Environmental Health Division
1675 W. Garden of the Gods Road
Suite 2044
Colorado Springs, CO 80907
(719) 578-3199 *phone*
(719) 578-3188 *fax*
www.elpasocountyhealth.org

TimberRidge Estates, SF-18-027

Please accept the following comments from El Paso County Public Health (EPCPH) regarding the project referenced above:

**EXTENDED DETENTION BASIN DETAIL**

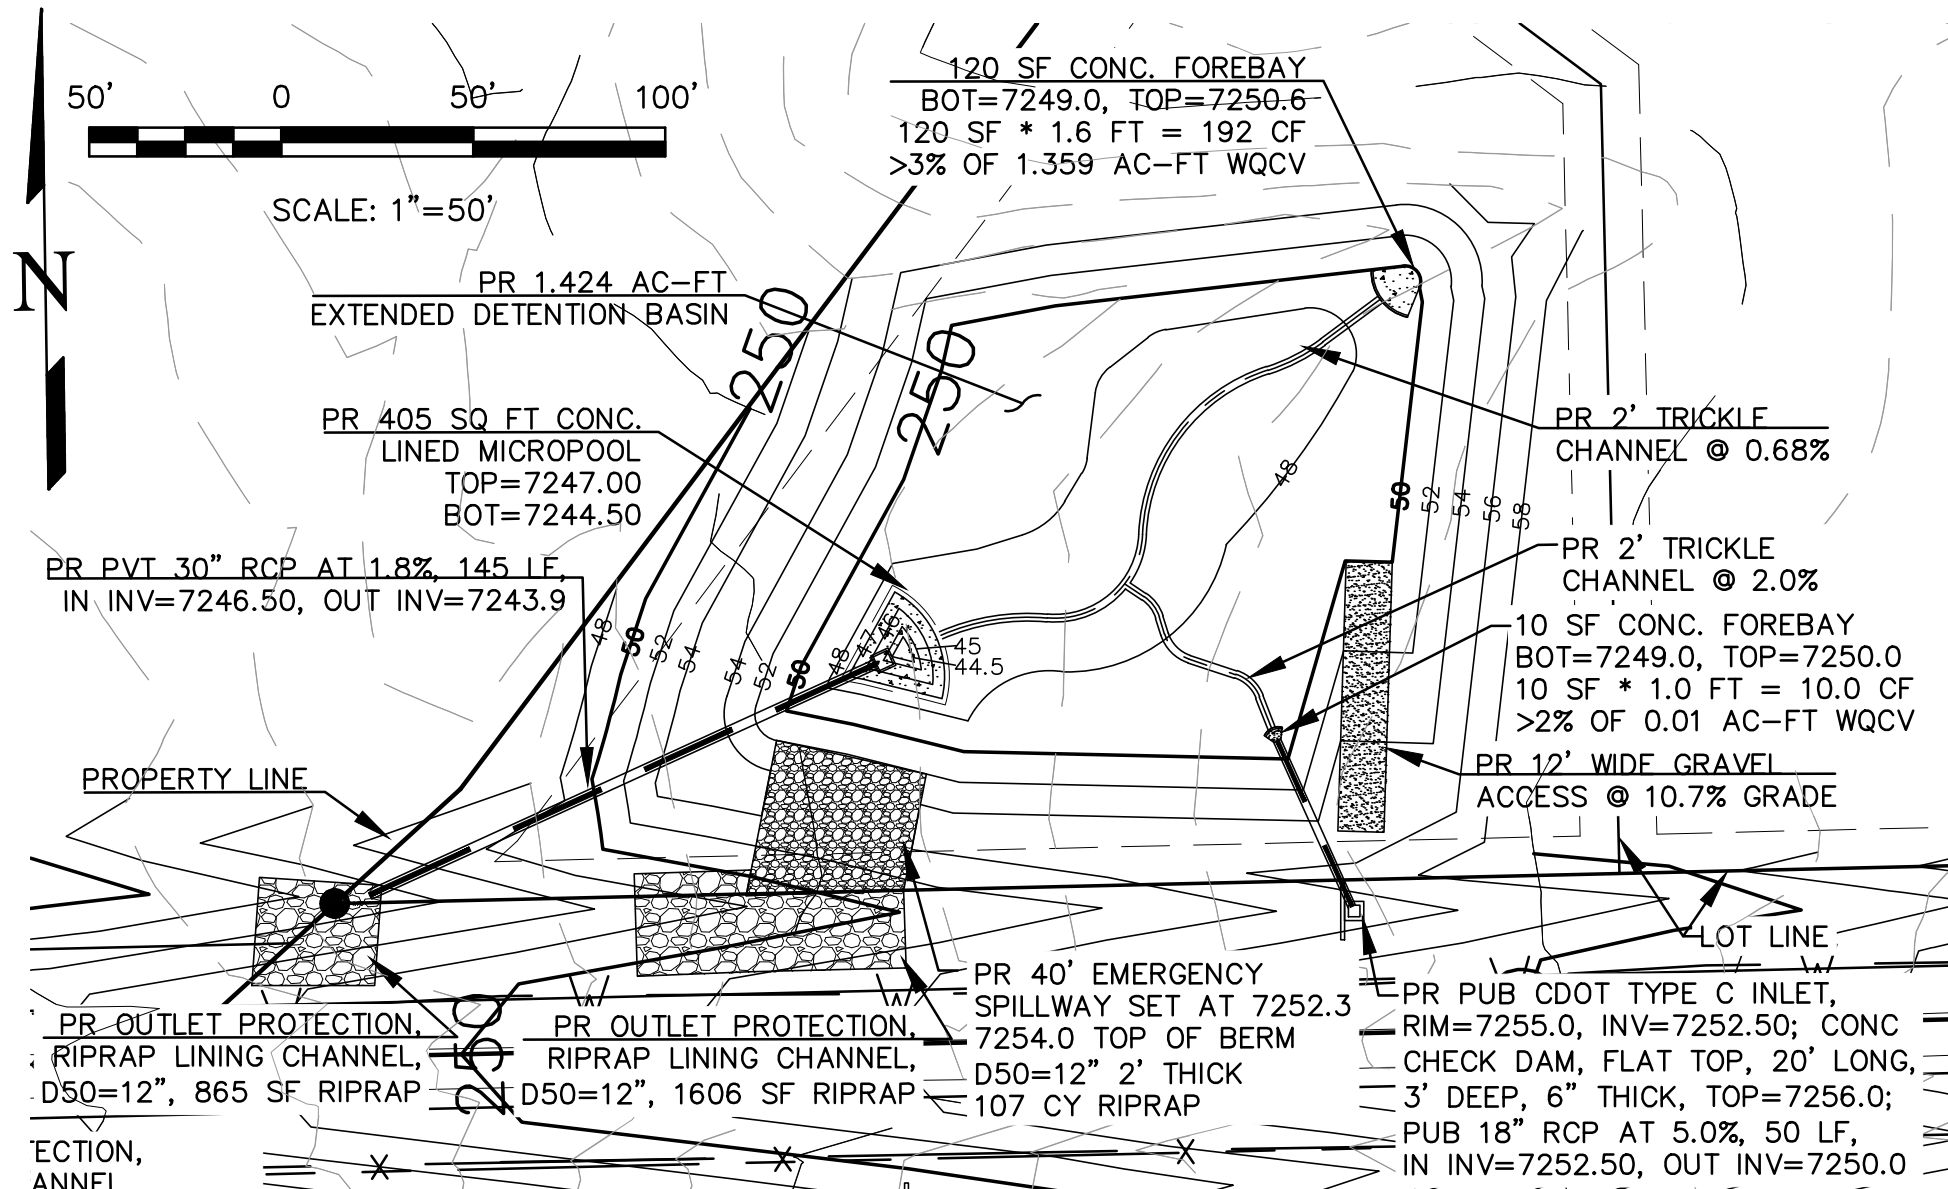
- The storm water detention basin in Tract A must have mosquito control responsibilities included as a part of the construction design and maintenance plan to help control mosquito breeding habitat and minimize the potential for West Nile Virus.
